Substantive response

Substantive response to the local planning authority (LPA) from the Health and Safety Executive (HSE) as a statutory consultee for developments that include a relevant building.

To LPA	Welwyn Hatfield
LPA planning ref no	6/2022/1355/MAJ
Our ref	Pgo-1988
Site address	Former Beales Hotel Comet Way Hatfield AL10 9NG
Proposal description	Demolition of existing building and construction of 145 residential units (Use Class C3) with private and communal amenity space, landscaping, access, associated car and cycle parking, refuse and recycling storage and supporting infrastructure.
Date on fire statement	24/05/2022
Date consultation received	22/09/2022
Date response sent	21/10/2022

Figure 2. Site Elevation, showing height measurements for each block measured from entrance level to topmost occupied floor.

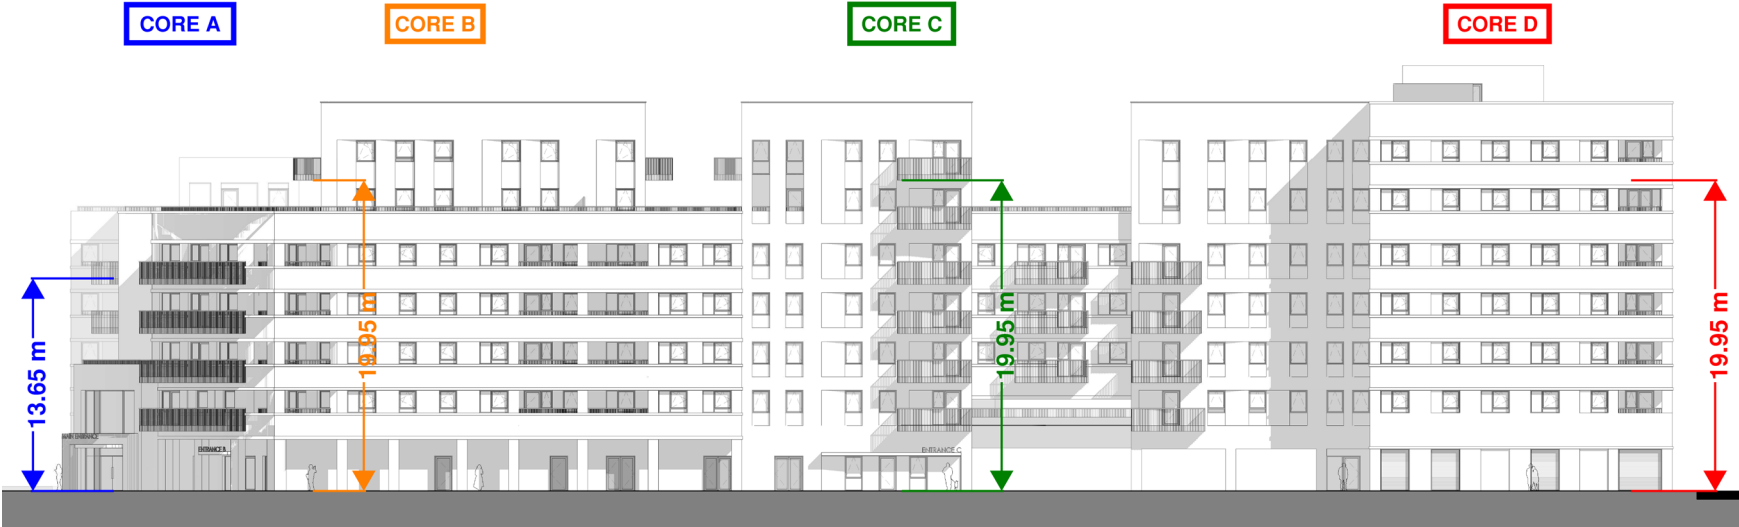
1.2 It is noted that this development will be one relevant building with separate cores i.e. single stair towers. The staircases represent the escape stair as well as the firefighting stair. There will be 4 separate single stair towers, detailed in this substantive response as Cores A – D. The heights of the cores are detailed below:

- Core A – 13.65 m (5 storeys)
- Core B – 19.95 m (7 storeys)
- Core C – 19.95 m (7 storeys)
- Core D – 19.95 m (7 storeys)

CORE A (6 STOREYS) 17.175M
CORE B (6 STOREYS) 17.175M
CORE C (6 STOREYS) 17.175M
CORE D (7 STOREYS) 17.175M

Figure 4. Communal roof terrace arrangement indicating stair cores in green, evacuation lift in yellow, travel distances in blue arrows and storey exit width measurements in red.

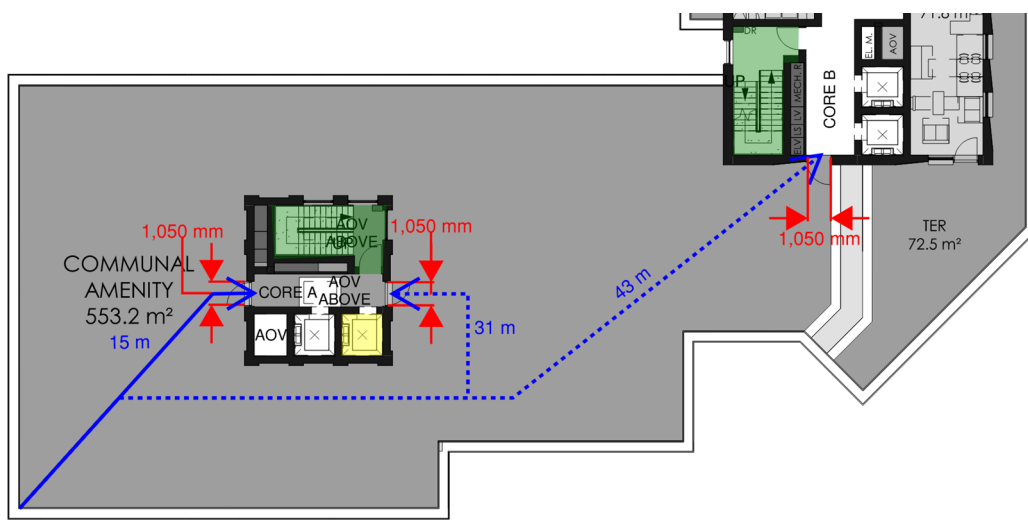
- 2.1 It is noted from section 7 of the fire statement that an occupancy of 512 persons has been calculated for the communal roof terrace. Should smoke enter stair core A, only one escape route would be available from this area i.e. via stair core B. This stair core would also be required for firefighting purposes. The occupancy figure of 512 persons is not suitable for this area. This will be subject to later regulatory consideration.

PLANS HAVE BEEN REVISED TO ADD THIRD ESCAPE ROUTE THROUGH CORE C
